From: Sheila Green [REDACTED]
Sent: 01 May 2012 12:07
To: Julie Grieves
Subject: RE: BR/101/12/L
Attachments: Clock face tower scales.pdf

| Technical Support Unit Assistant, Planning and Building Control, Arun District Council | Location: First Floor, Arun Civic Centre, Maltravers Road, Littlehampton, BN17 5LF

SOUTH FACING SIDE
OF BUILDING

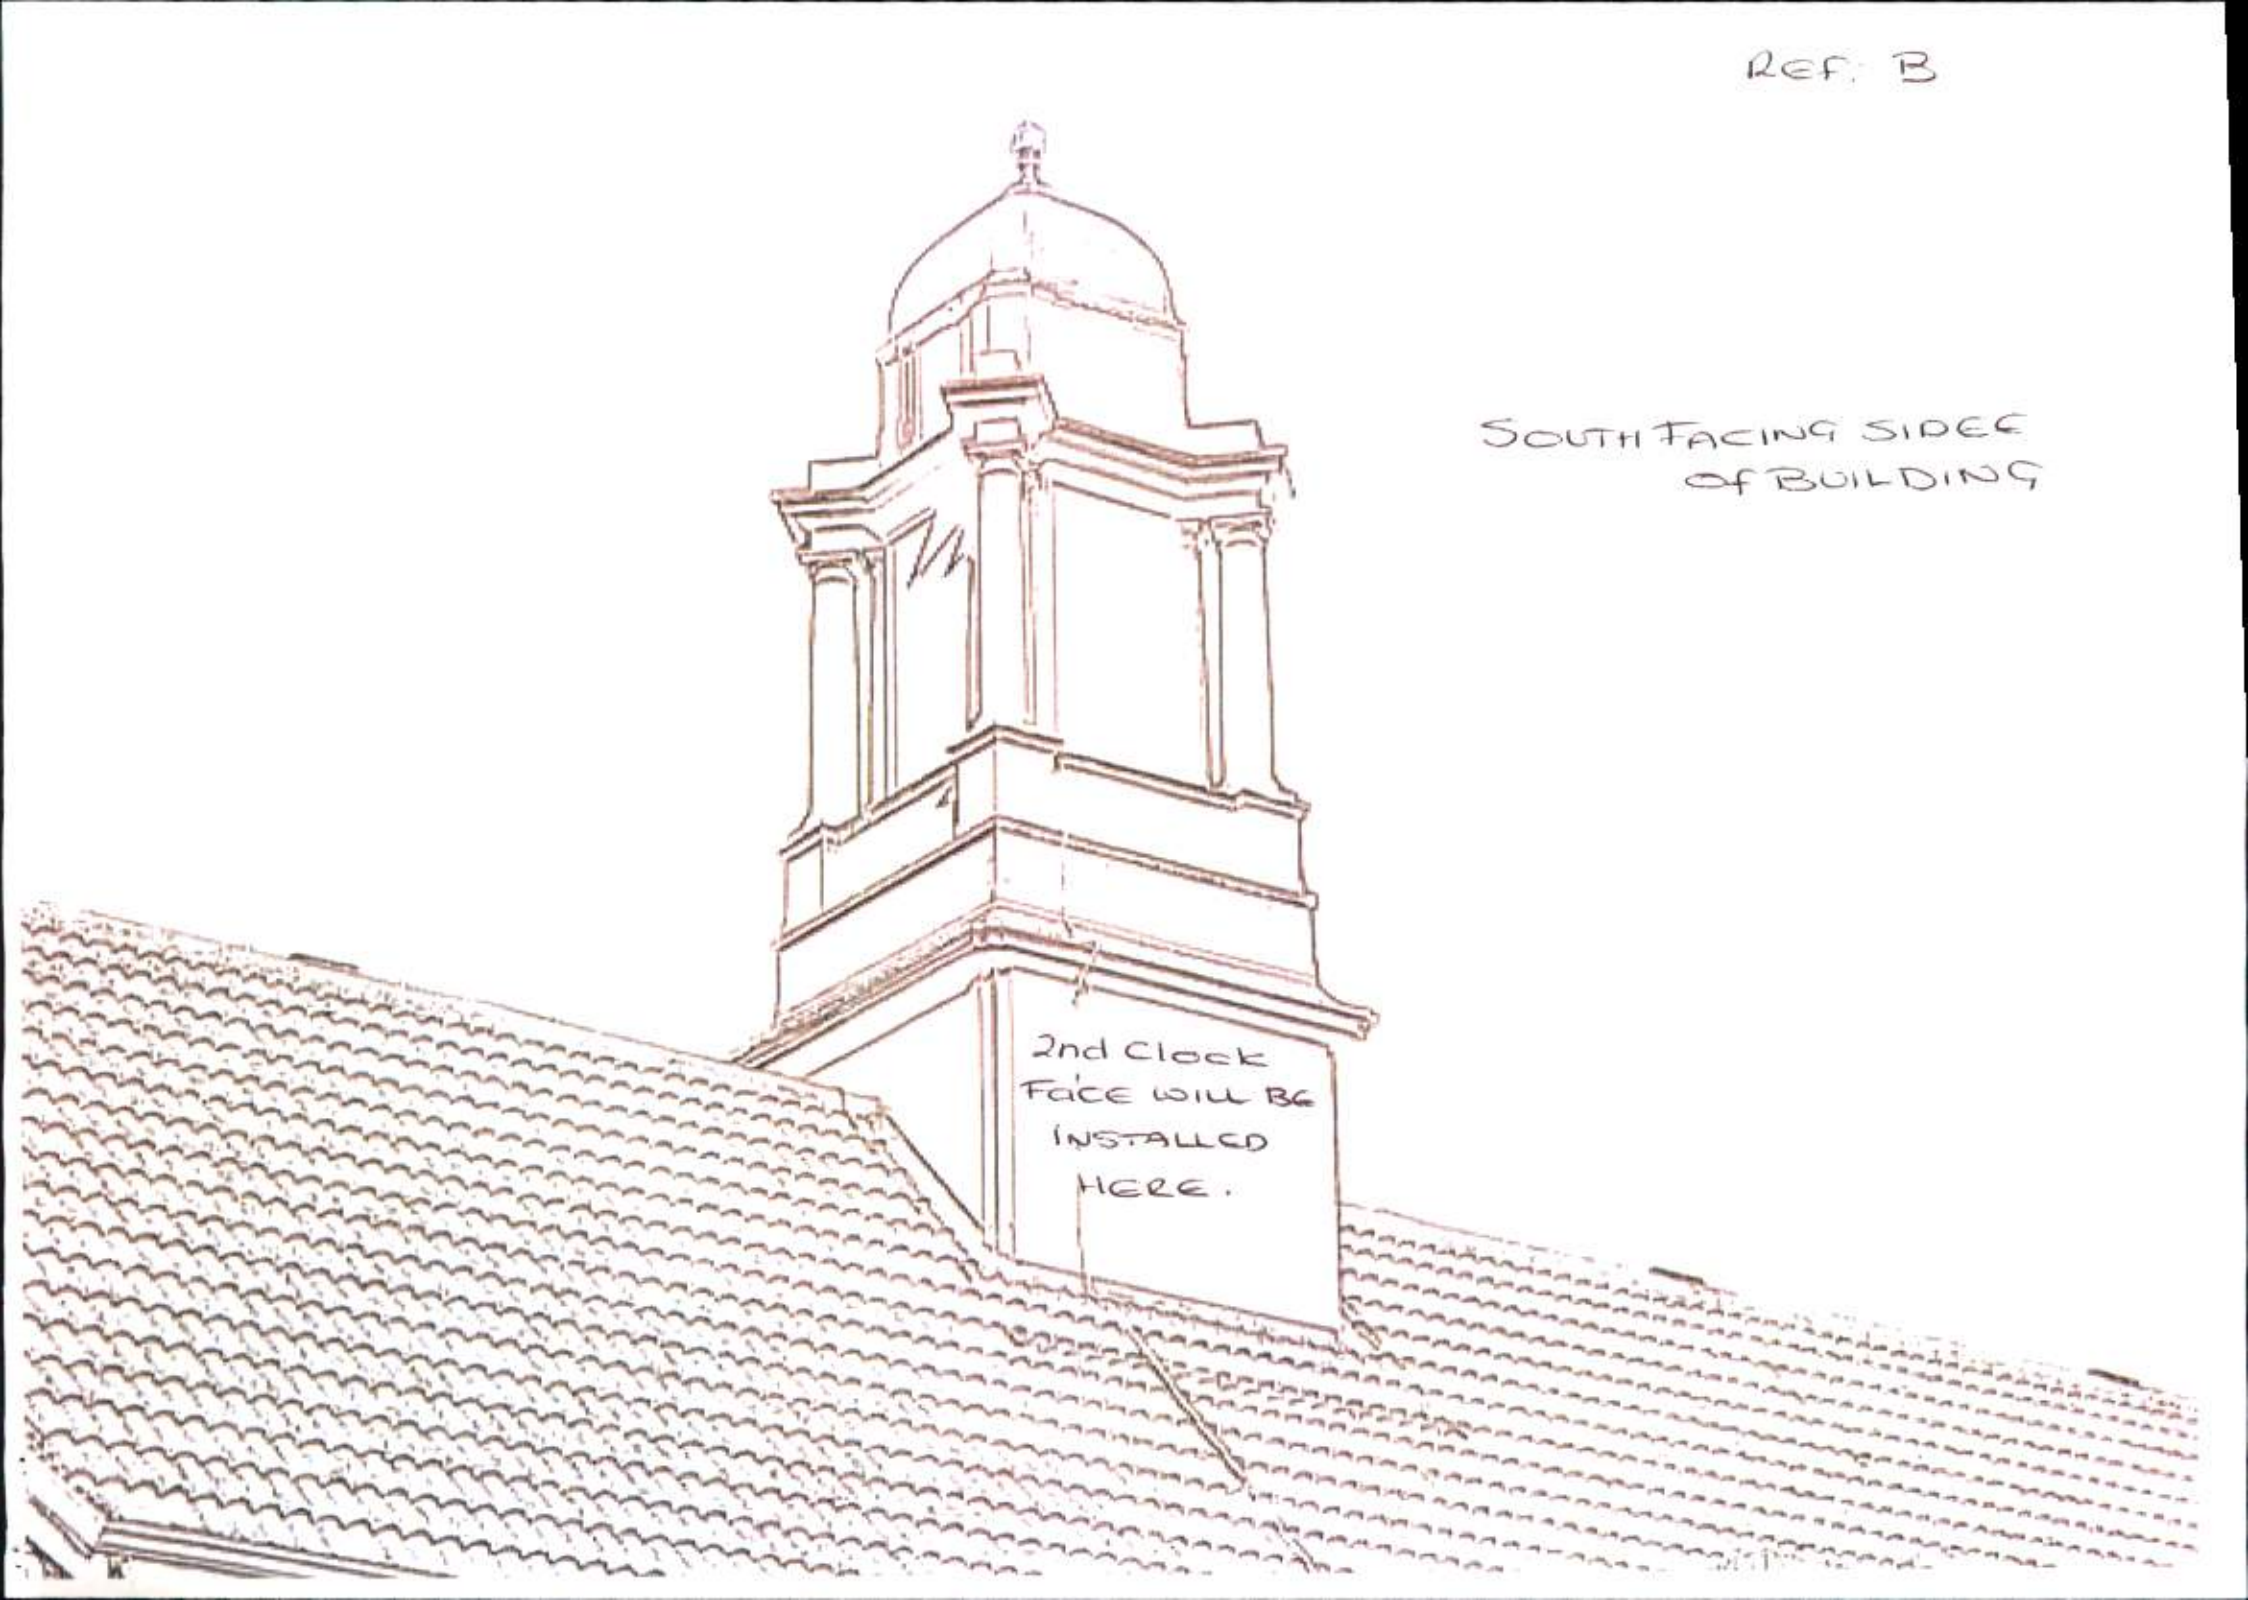
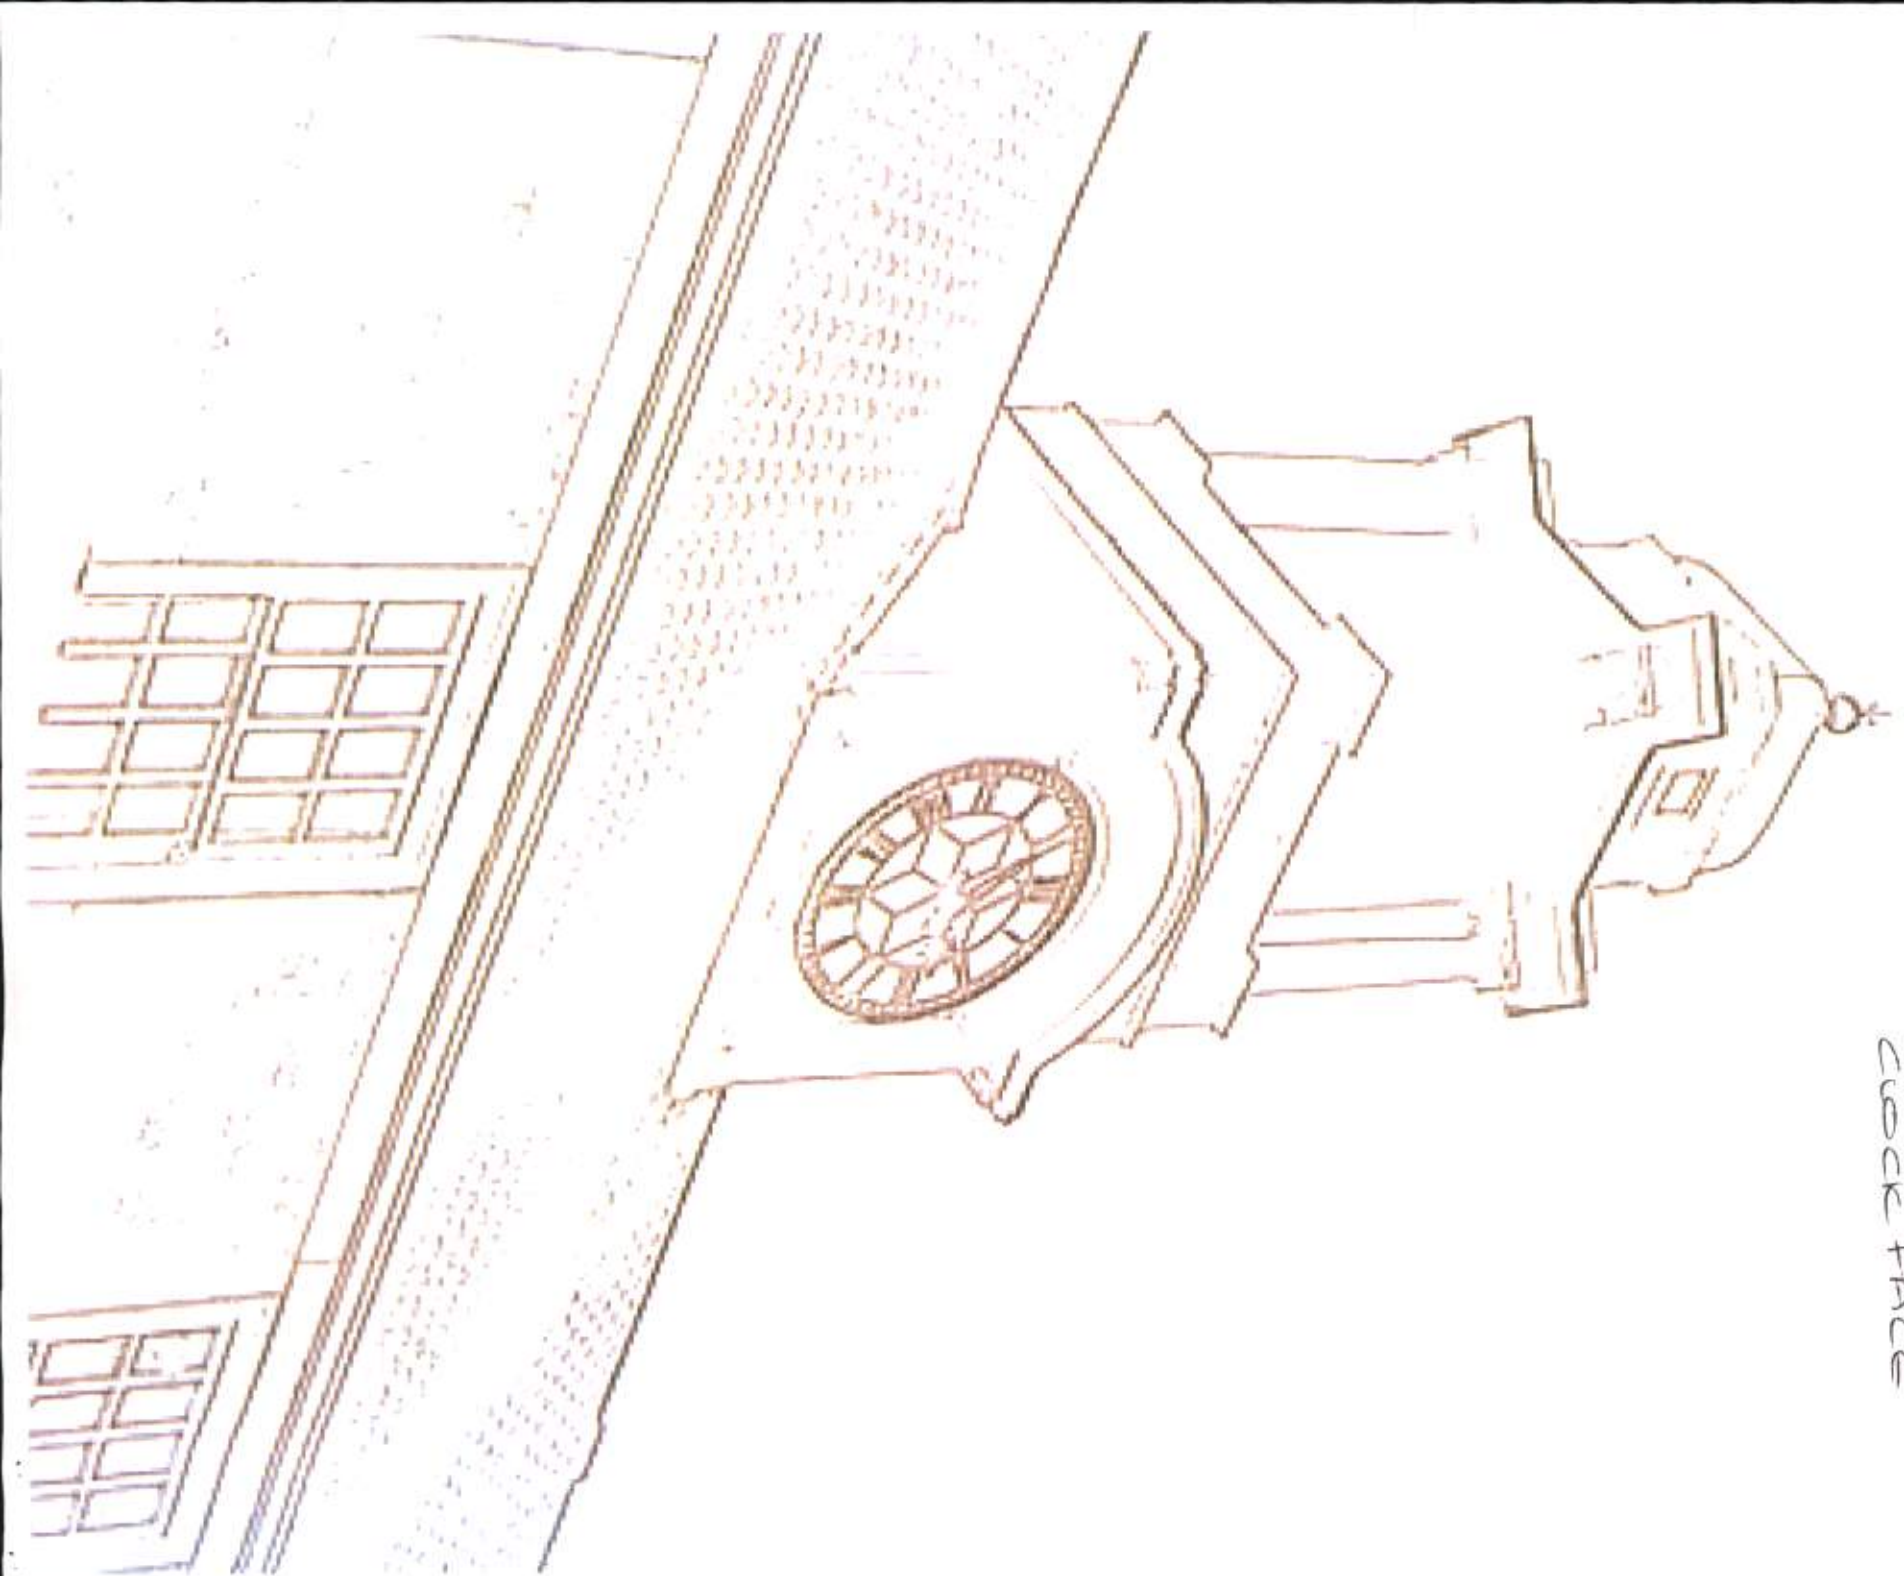
I'm just printing these plans out and see that they don't have a scale written on them. Can you amend and re-send and then hopefully that is it! (along with the measured clock face)

I have attached a copy of the clock face with the measurements and another copy of the tower with the scales. I hope this is what you meant.
